**Westergate Highways
Proposed Housing Development**

Stage 1 Road Safety Audit

Date: 25/03/08
Reference: E-G6828.00
Status: FINAL

This report results from a Stage 1 and 2 Road Safety Audit of the proposed access relocation at The Homestead, Westergate Street, Westergate following a request to carry out this review by Andy Traves of Opus International Consultants (UK) Ltd (Fareham). The Audit was undertaken by Anna Partridge and Mark Andrews

Drg.Title: SURFACE FINISHES

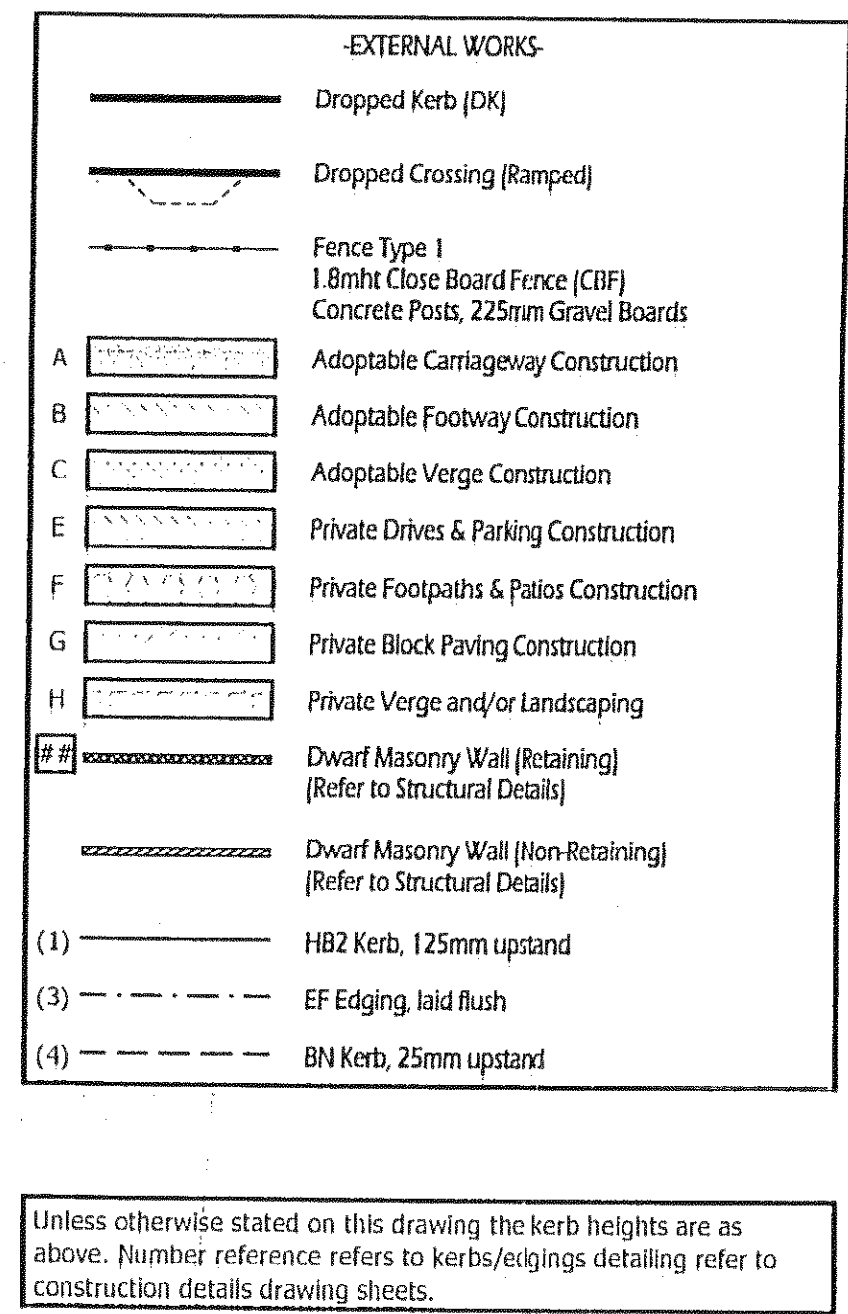
The information provided for audit does not contain any specific information regarding the drainage of the site. Failure to provide adequate drainage could result in ponding and present road users with a potential slip hazard particularly in cold weather.

The information provided for audit does not contain any specific information regarding the proposed planting at the re-grading of the verge. Inappropriate planting could result in an obstruction of the visibility.

The information provided for audit shows no details of warning signs for the access. Without adequate and suitable signage it is possible that other road users may approach the new access unaware of the nature of the facility

The design team must ensure that adequate drainage is provided throughout the proposals.

The design team must ensure that the planting is such the visibility at the junction is not compromised. Low level planting should be used, with an adequate maintenance regime in place.

It is essential that the design team include suitable and sufficient signage for the nature of the access to inform other road users of the facility.
